SF2017/231533; WST17/00158/02

SSD8777: Lots 1 and 2 DP 1095725, Lot 2 DP 573426 and Lot 1 DP 1006557; 'Waroona' 121 Maryvale Road and 'Scarborough House' 801 Cobbora Road (MR353), Maryvale; Maryvale Solar Farm Environmental Impact Statement

Roads and Maritime Services

APPENDIX 6: ROAD UPGRADES AND SITE ACCESS

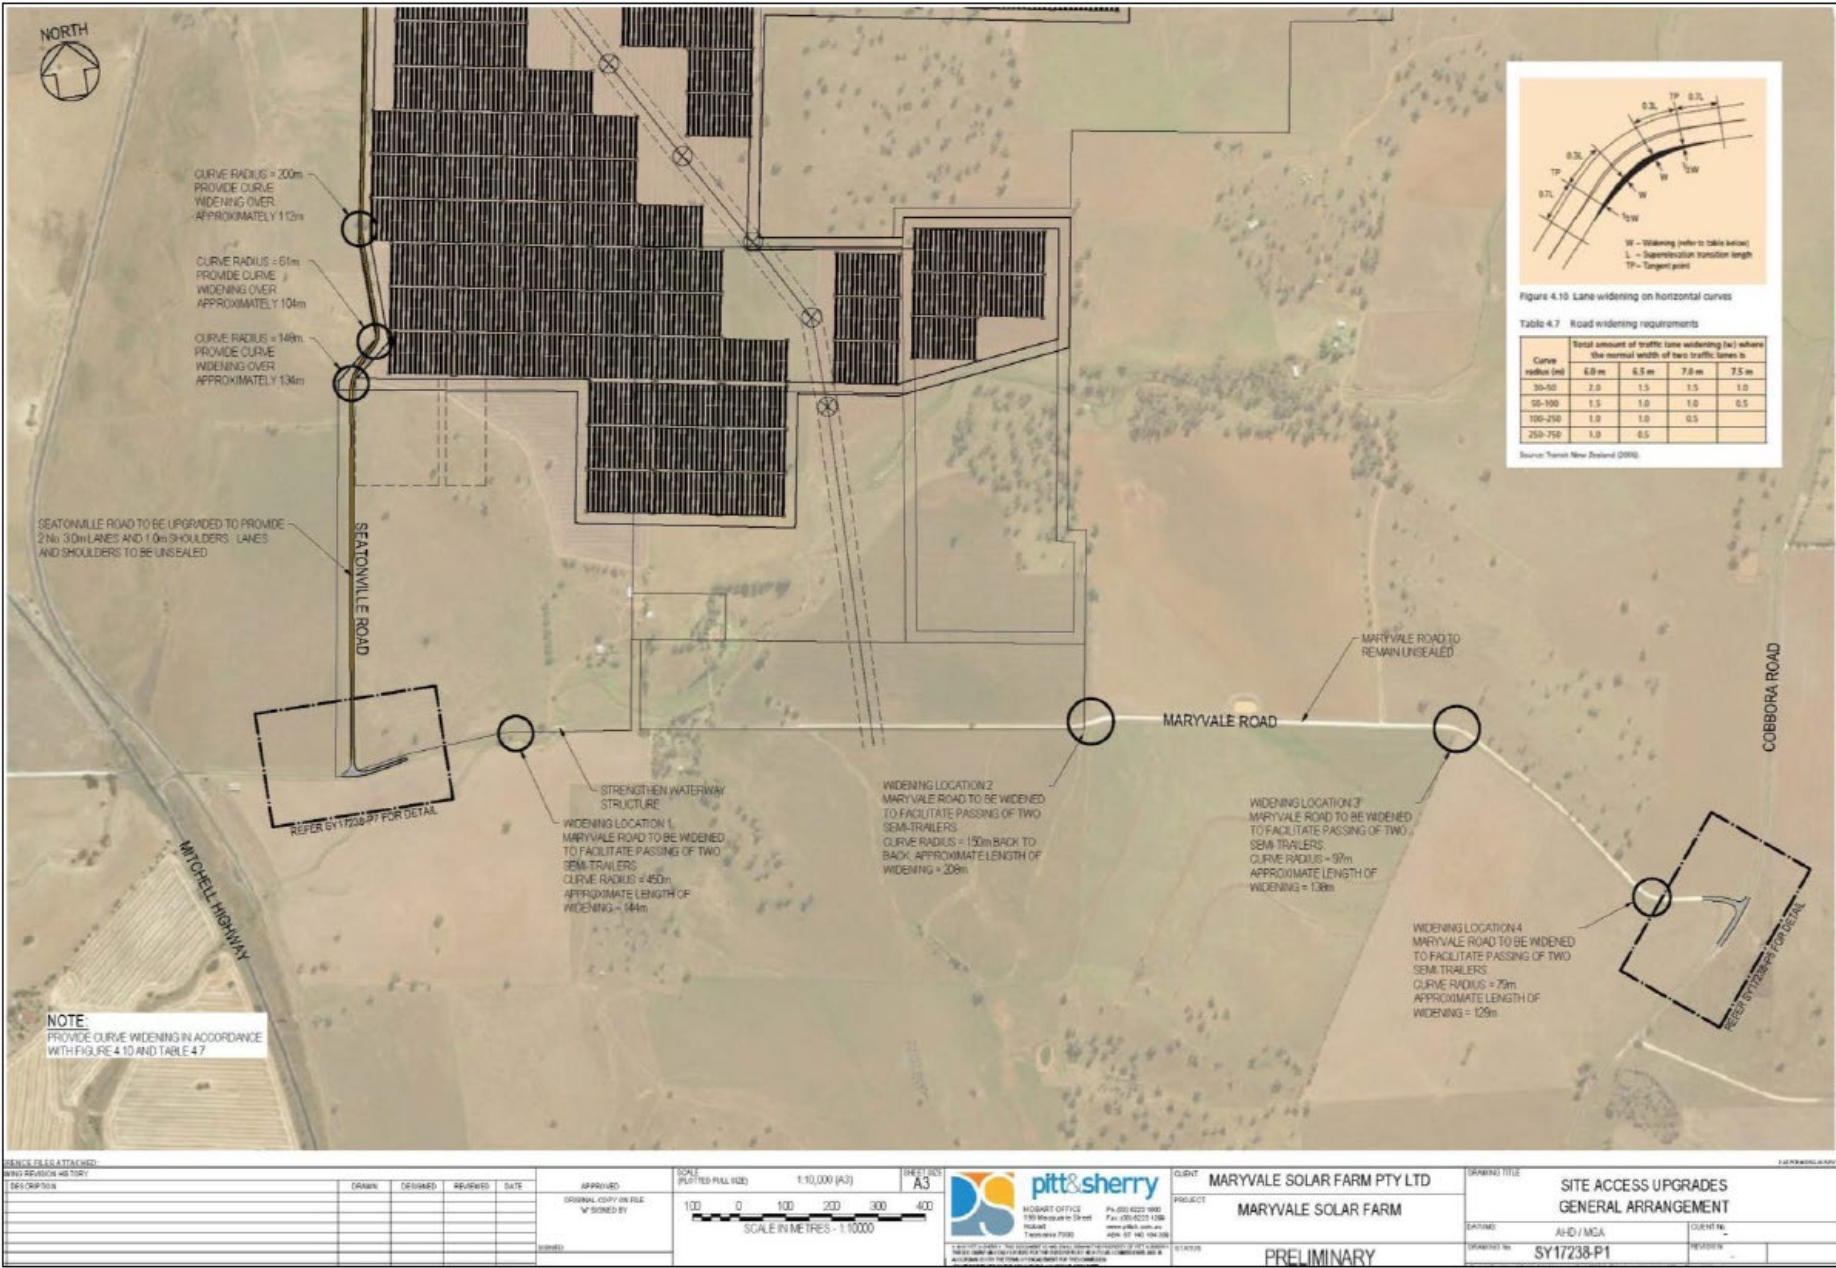
The documentation submitted in support of the proposed development has been reviewed. Roads and Maritime Services is supportive of the proponent's commitment for all solar farm related traffic to access the site via Cobbora, Maryvale and Seatonville Roads, with no vehicle movements through the intersection of the Mitchell Highway (HW7) and Maryvale Road. Roads and Maritime is also supportive of the proposed upgrade to the Cobbora Road intersection with Maryvale Road, however, Roads and Maritime does not support the proposal to reduce the speed zone through this intersection to compensate for lack of sight distance. Roads and Maritime requests the proponent investigates the level of works required to achieve, in accordance with *Austrroads Guide to Road Design*, adequate sight distance at the Cobbora/Maryvale Road intersection.
